From: Simon Davis
Sent: 12 December 2017 11:44
To: 'hdaprojects'
Subject: AW/306/17/HH - 4 Apple Grove

Title
Plans as Proposed

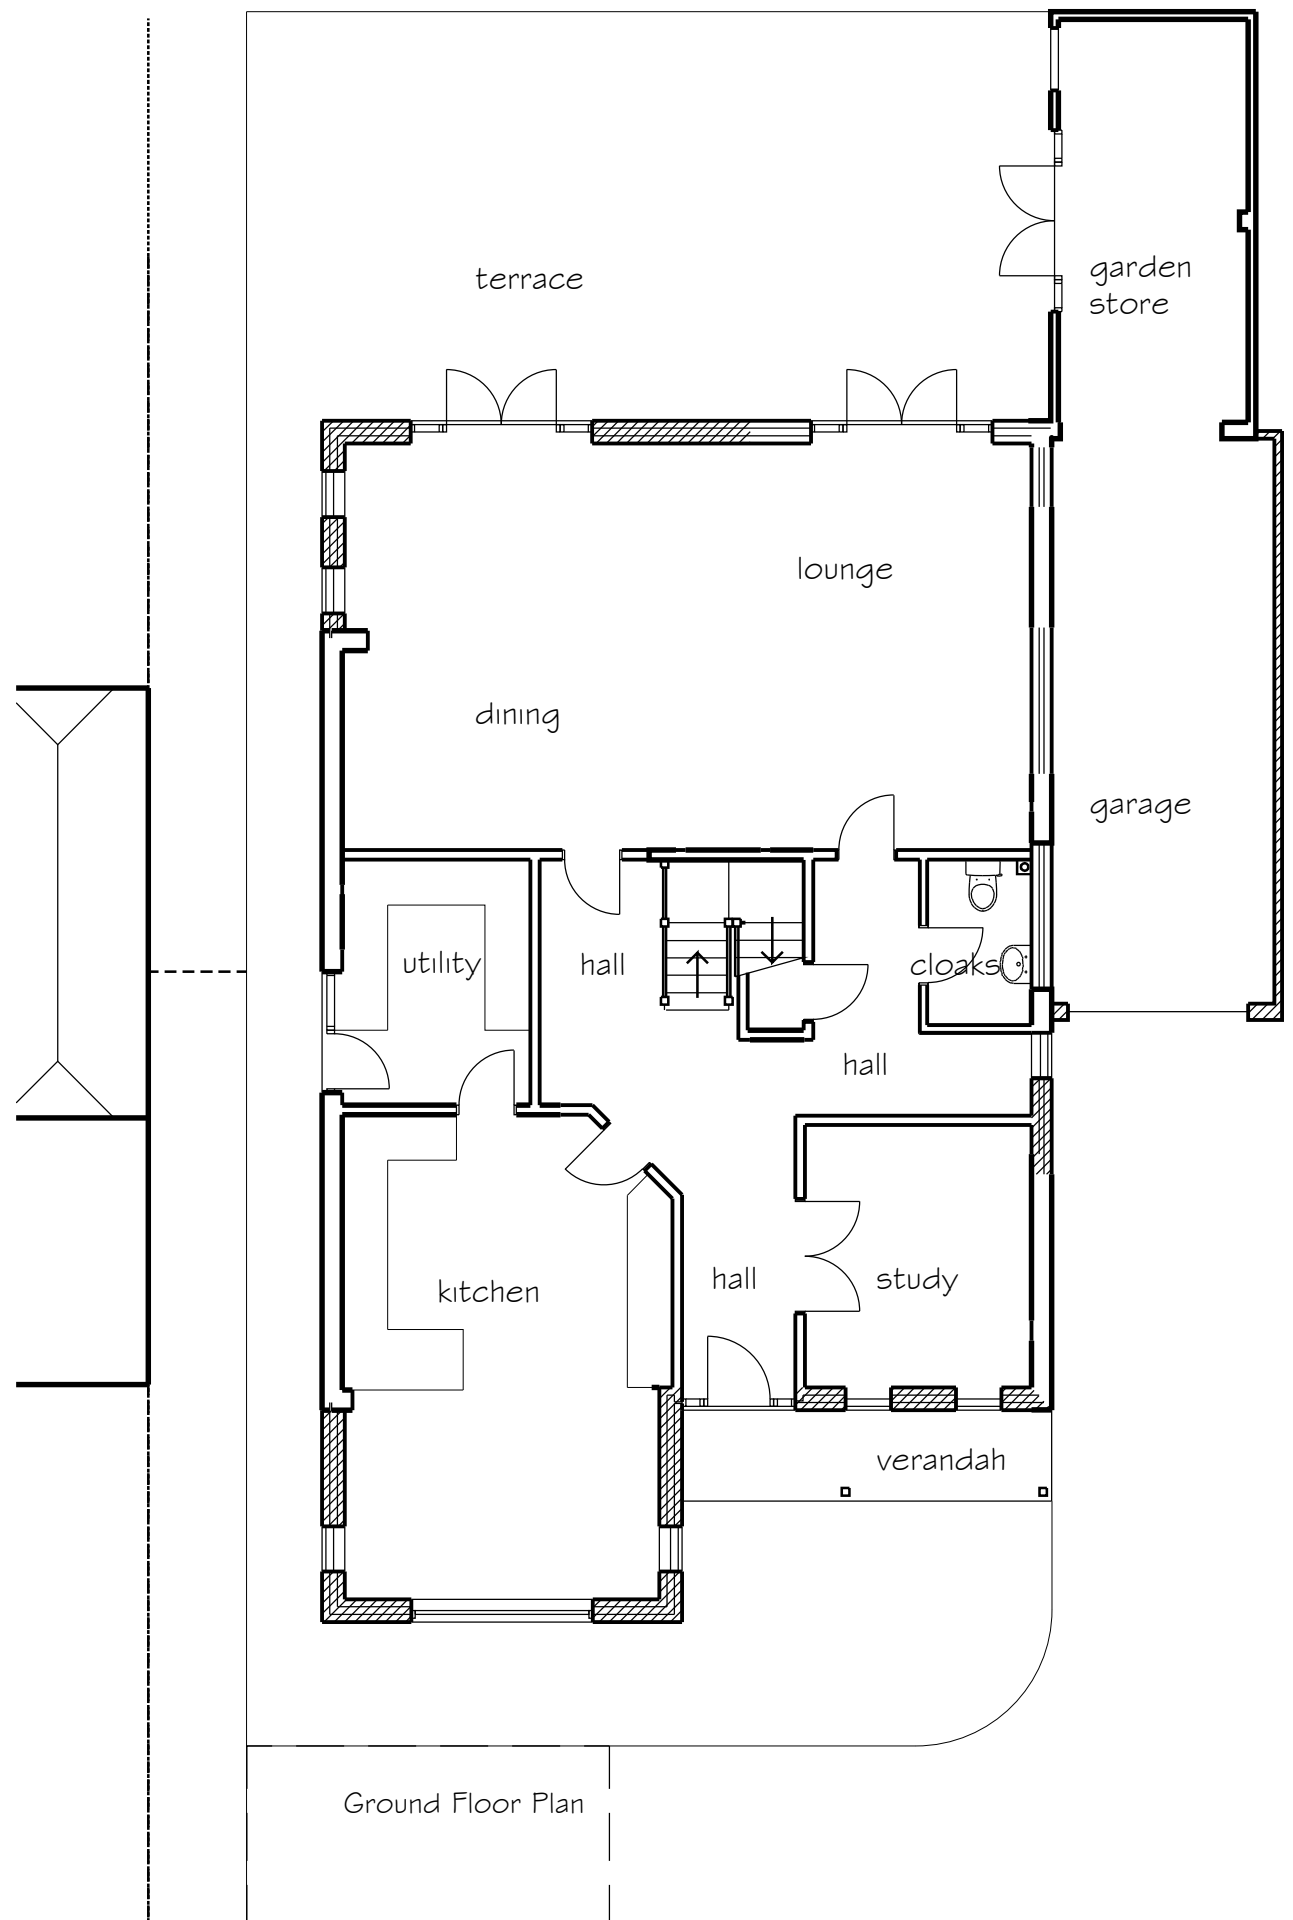
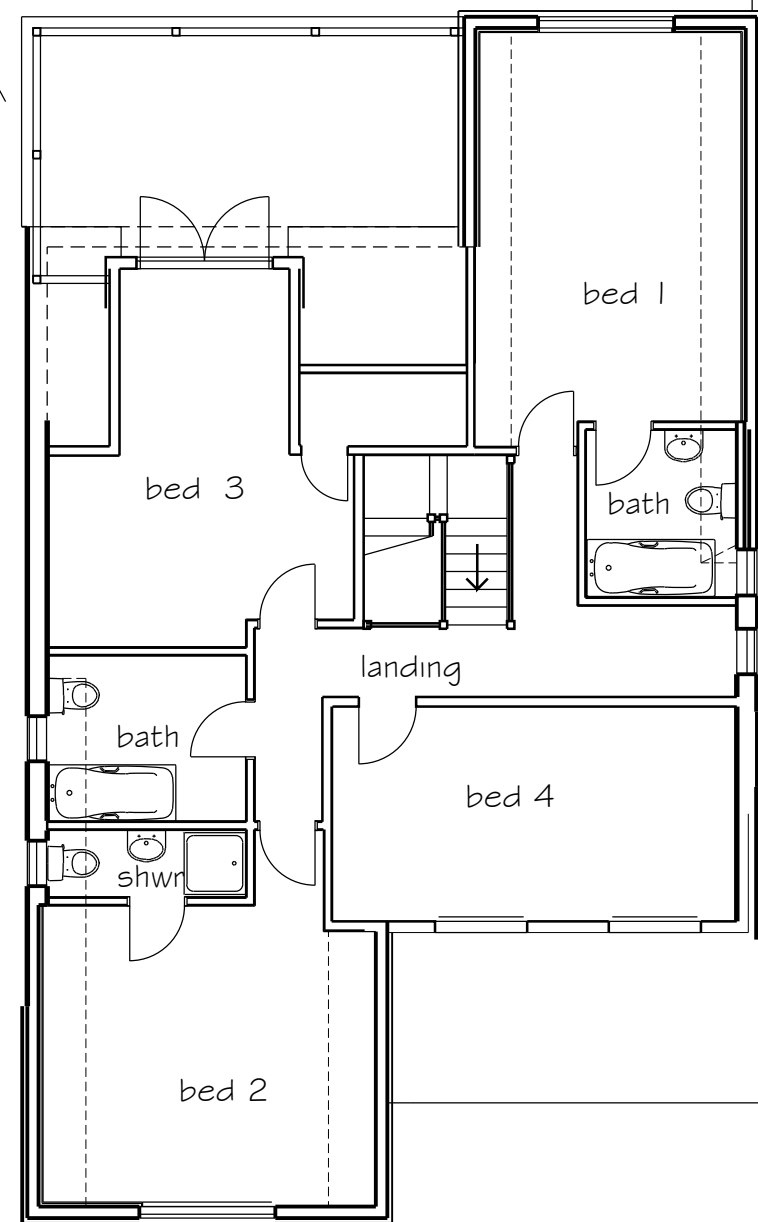
I have today spoken to the applicant (she rang me) and told her I will be approving this sometime in January. I mentioned to her that I would need an amendment in respect of the side of the balcony facing no. 5. I need you to amend the drawings to show a 1.8m high obscure glazed or solid side screen to this side of the balcony. Are you able to do this?
